Town & Country Planning Act 1990 (as amended)
Town and Country Planning (Development Management Procedure) (England) Order 2015
Approval of details reserved by condition imposed under BR/281/18/PL relating to conditions 3-
Arboricultural meeting, 6-Construction Management Plan, 7-landscape scheme, 8-colour scheme of
materials and/or finishes, 9-new screen walls and/or fences, 10-covered and secure cycle parking
spaces, 12-dustbin enclosures, 13-electric vehicle charging & 14-decentralised, renewable and low
carbon energy supply systems.
99 Victoria Drive Bognor Regis PO21 2DZ

Condition Number 13

Arun District Council have decided to **APPROVE details reserved by this condition**

PROPOSED SITE/LANDSCAPE PLAN

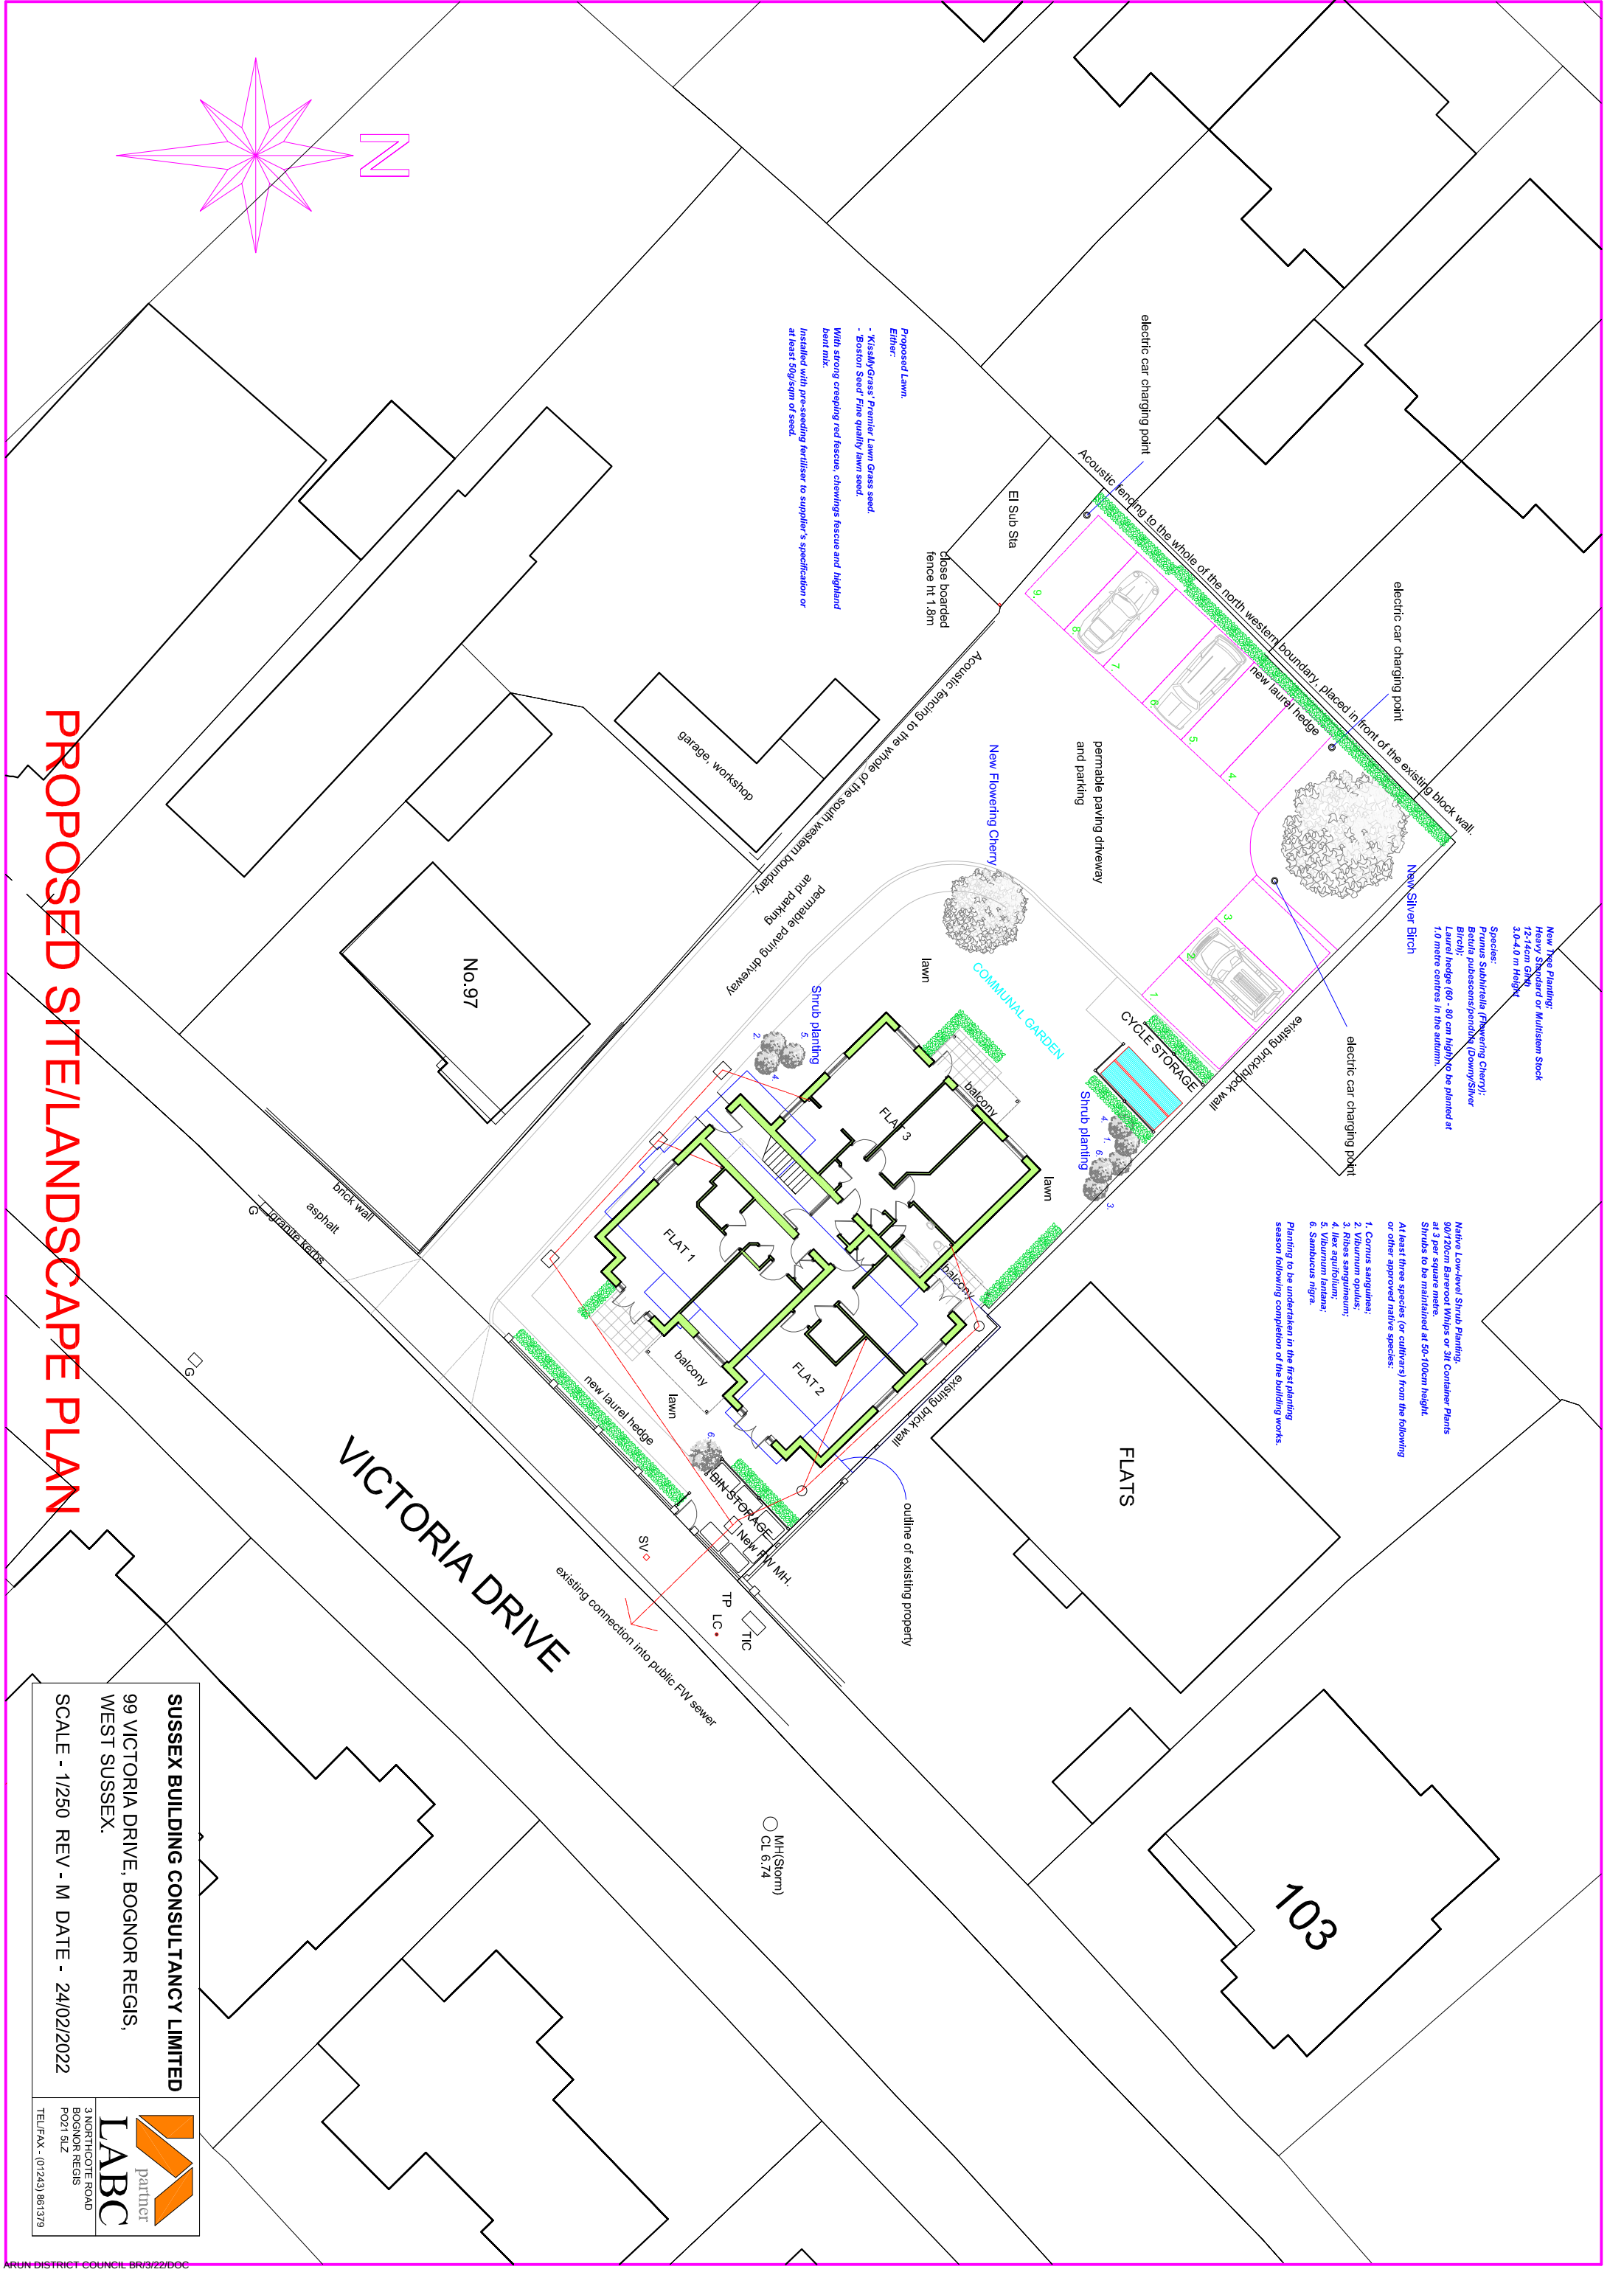
The details and further information required in respect of the electric car charging points and their location demonstrated as shown on amended Site/Landscape Plan have been reviewed by the ADC Environmental Health Officer. On the basis that the EV charging points will be installed in the locations specified in submitted drawing the condition can be discharged.

The condition is therefore fully discharged on the understanding that you will implement the charge points in accordance with the approved details and that these will be permanently retained in a condition that is fit for purpose.
